Consultation Response from KC, Highways Development Management
2024/93536 Homelea, The Knowle, Shepley, Huddersfield, HD8 8EA
Alterations to convert integral garage into living space, erection of attached garage and formation of new driveway access
Date Responded: 07/02/2025 Responding Officer: CNB Responding Ref: K12-39/29

PROJECT:	Holmlea, The Knowle, Shepley, Huddersfield			
CLIENT:	Mr. M.Smith			
DRAWING:	Proposed L-Ground Floor & Roofplan			
DRAWN BY:	DB	CHECKED BY:	GG	CREATED: 03/12/2024 SCALE: 1:100 @ A3
STATUS:	Developed Design		DRAWING No: 1499/P2-102	REVISION:

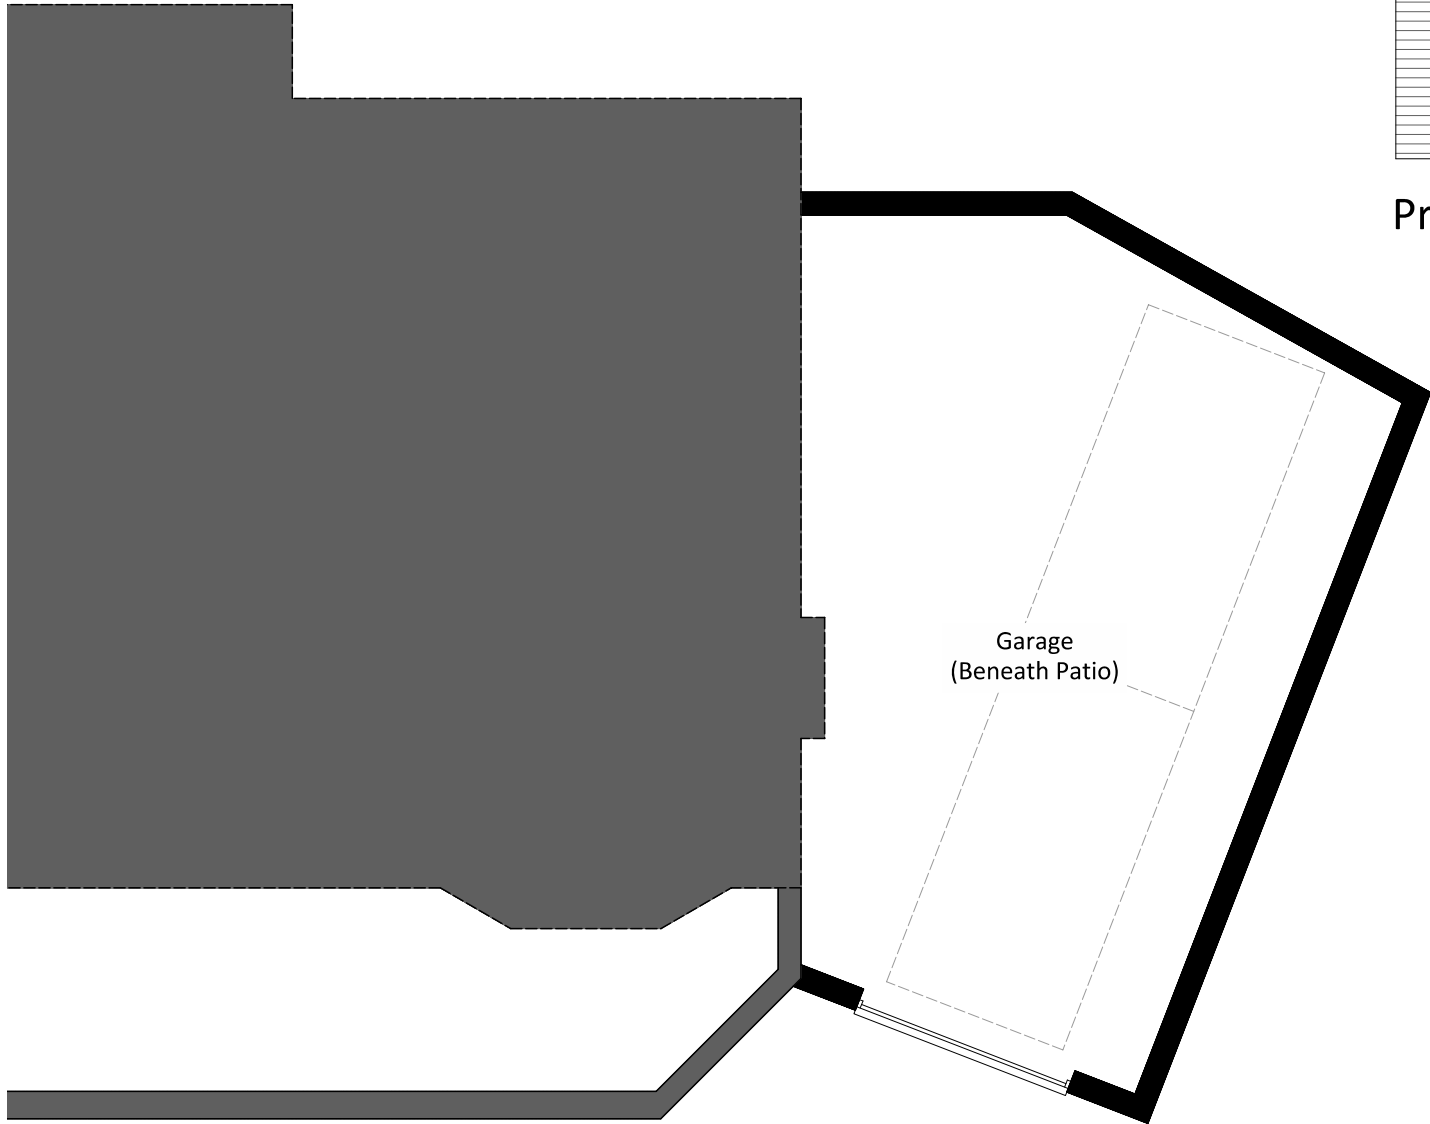
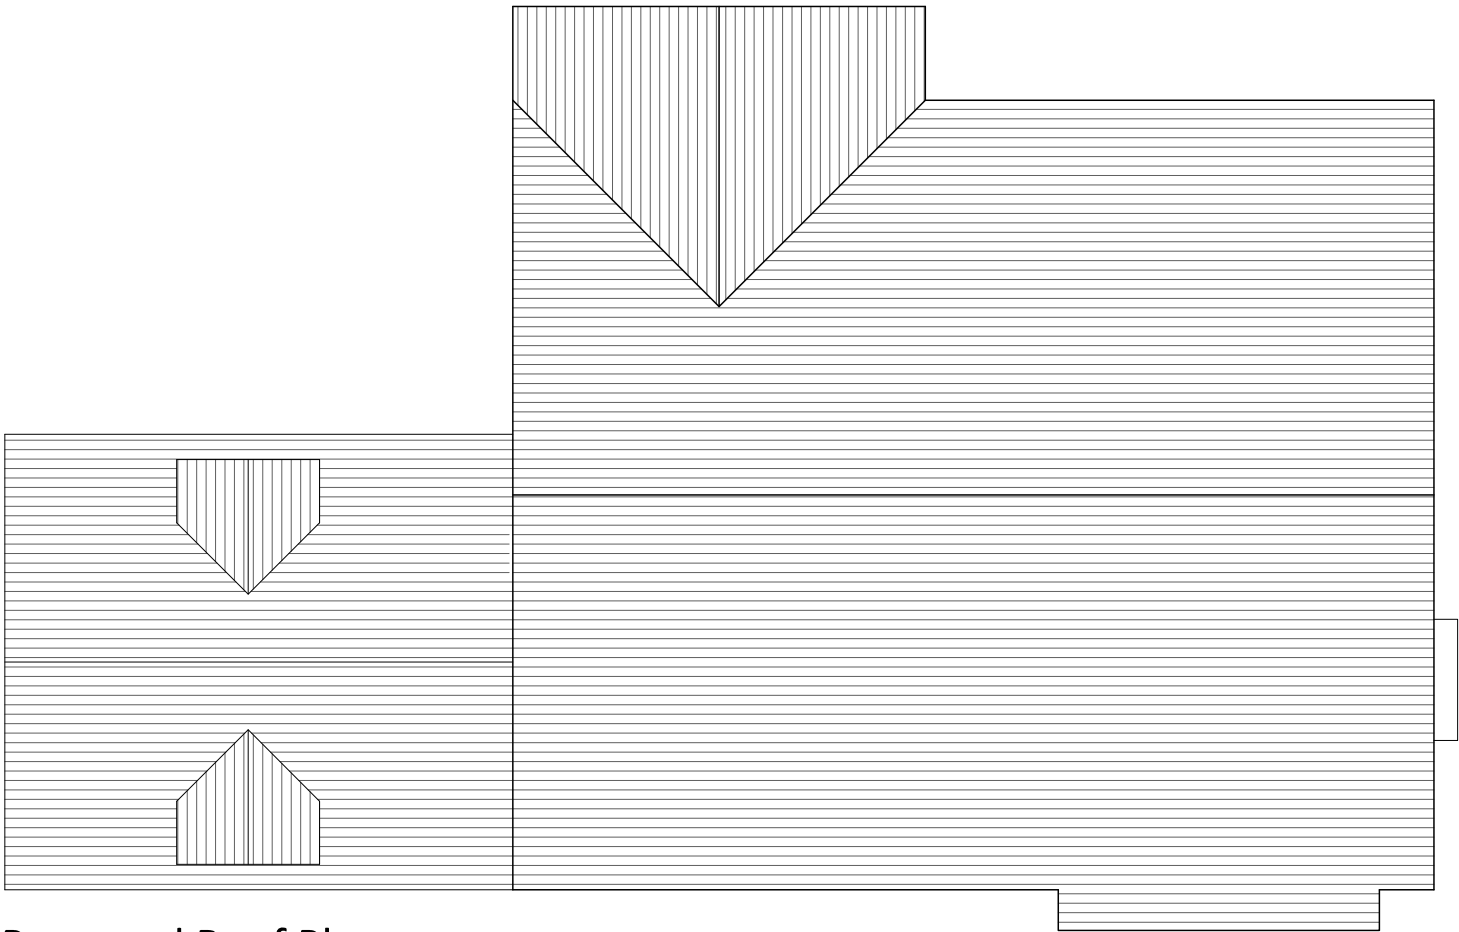
The new access will be located approximately 16m to the north west of its current location and would serve the proposed double garage and driveway that allows for turning on site so cars can enter and exit the site in forward gear for highway safety reasons.

The proposed new location of the access is on the apex of a bend on The Knowle and would provide suitable visibility splays in both directions.

The residential development to the west of The Knowle (approval 24/90991) has a 3m footpath/cycleway linking the development to The Knowle and there were concerns raised that this ped/cyclist access would be in conflict with the proposed new vehicular access, however the two access points will be approximately 30m apart and suitable visibility between the two is available and so this is not viewed as a highway safety concern. The new 3m residential development access would be expected to generate an increase in pedestrian/cyclist use on The Knowle, however the current application would not generate any additional vehicular traffic on The Knowle.

Notwithstanding the provisions of the Town and Country Planning (General Permitted Development) Order 1995, (or any order revoking and re-enacting that order) any gates or barriers for or over a vehicular access or egress shall be hung as to only open inwards. So long as such gates or barriers are in position they shall be retained to only open inwards.
